SUBJECT: SF-17-024 –Sterling Ranch MDDP - First Submittal - Response Letter

MDDP

2018 STERLING RANCH MDDP		EXISTING HYDROLOGIC CONDITIONS MAP	
PROJECT NO. 08-035	FILE: \\dwg\Eng Exhibits\2018-MDDP-ExistCond\SWMap-REVISED.COLORS - .dwg	SCALE	DATE: 07-22-16
DESIGNED BY: DLM	DRAWN BY: DLM	HORIZ: NTS	VERT: NTS
CHECKED BY: VAS			DM1

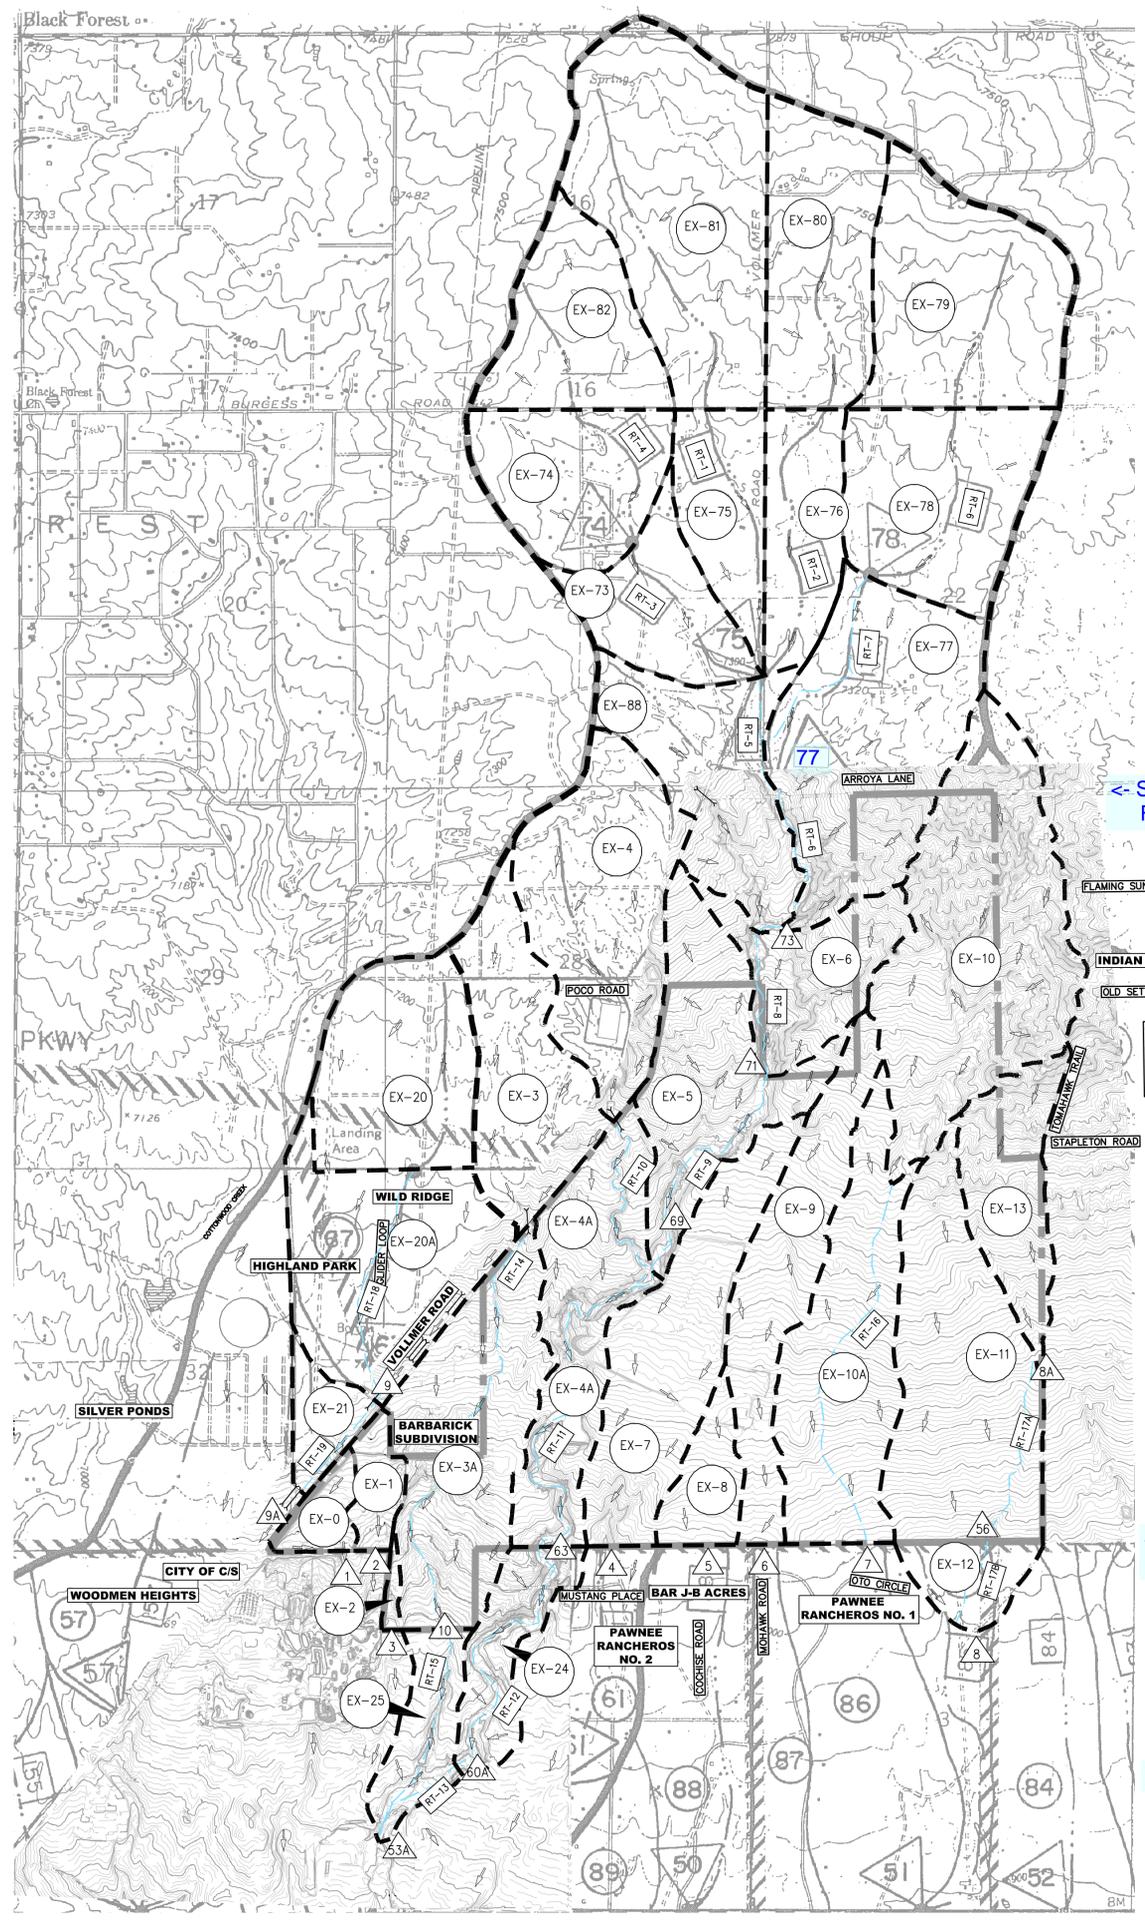
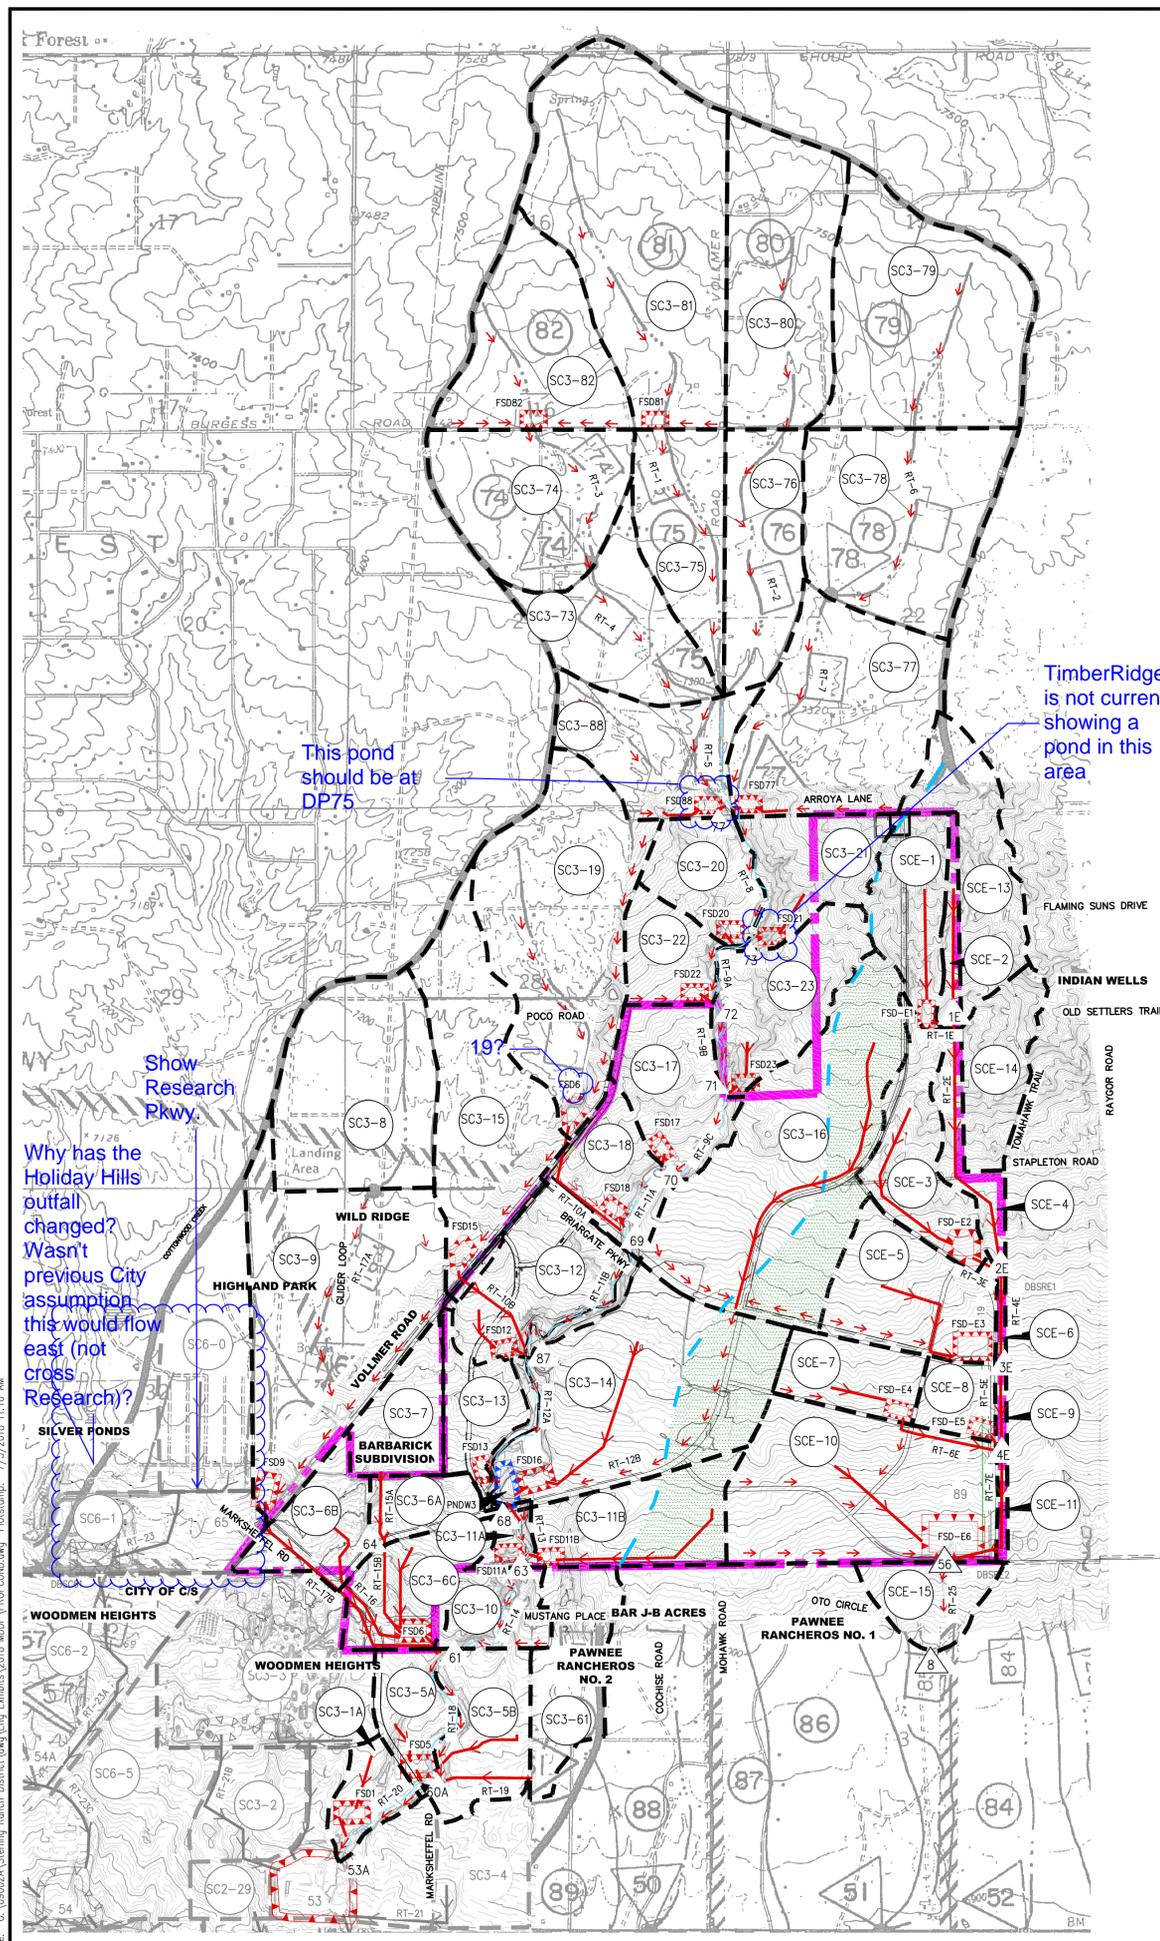
- a. Label DBPS design points and flows on both existing and proposed plans. **Done**
 - b. Label FEMA flows at least at the property lines. **Done**
 - c. Adjust the anticipated upstream FSD pond locations based on the current TimberRidge plans. **Done, the MDDP has been updated to reflect the latest Timber Ridge Preliminary Drainage Report.**

**STERLING RANCH POND W-3**

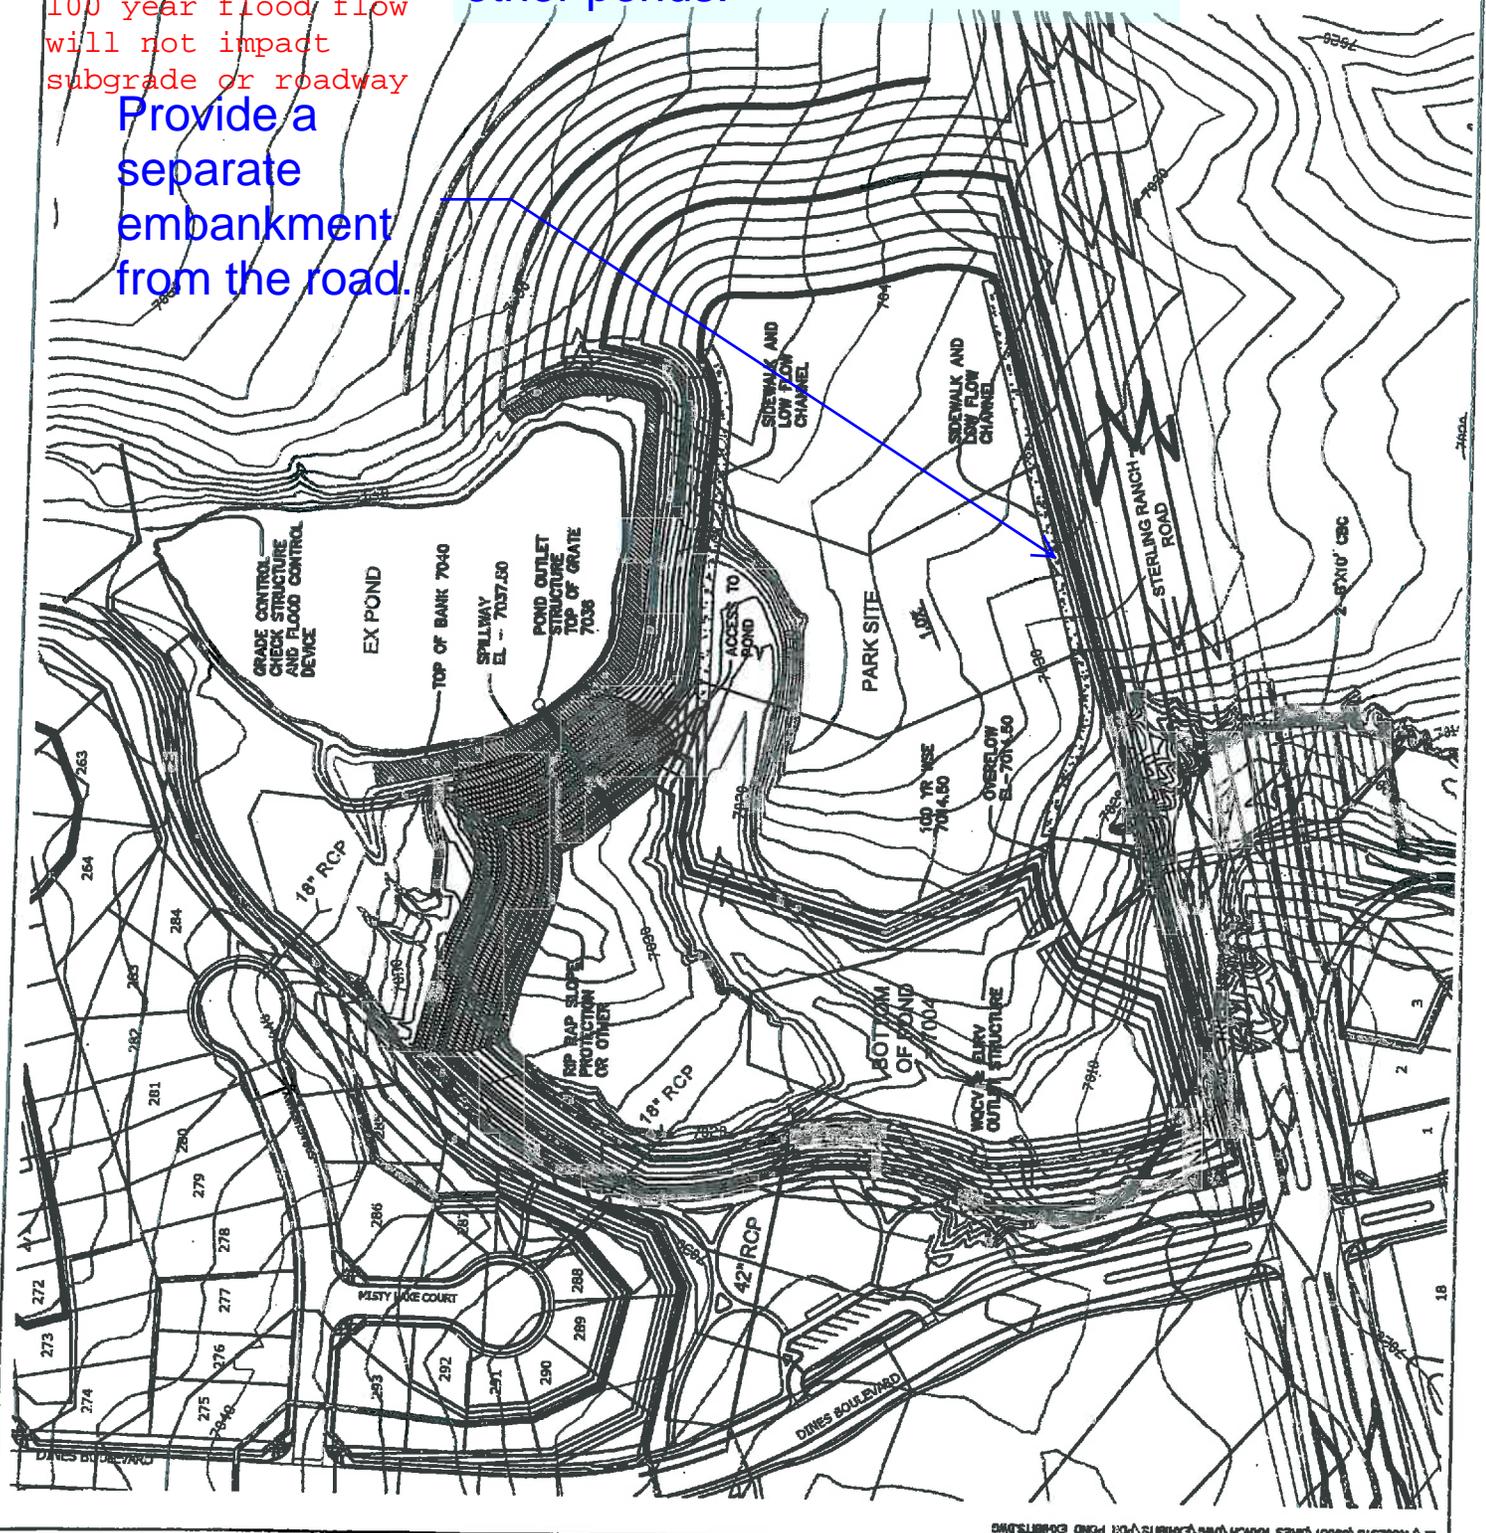
8. More detail is necessary to confirm the conceptual design for Pond W-3:
 - a. Attenuation of increased flows and volumes from both higher development intensity and the diverted East Fork flows need to be thoroughly addressed. The deviation request for the diversion needs to include this information. **The sole reason of Pond W3 is for this purpose. The description of the conceptual design is to address this proposed condition. The deviation request also discusses the purpose and solution.**

- b. Approval of the MDDP does not imply approval of conceptual design details for this pond. The pond should be revised not to use the road as an embankment unless the outlet structure is designed to handle undetained developed flows. **The preliminary design of Pond W-3 anticipates using the embankment outlet structure to handle undetained developed flows. The design in the MDDP is considered conceptual.**

- c. The report states that the pond is online; additional detail will be required addressing SB15-212/ §37-92-602(8) CRS Compliance rules in regard to the facility being in the Fountain Creek basin. **The purpose of Pond W3 is for detention to attenuate the**

increase flows from the proposed diversion only. Therefore, no water quality facilities are proposed in the conceptual design. All facilities will be design to comply with state water rights statues
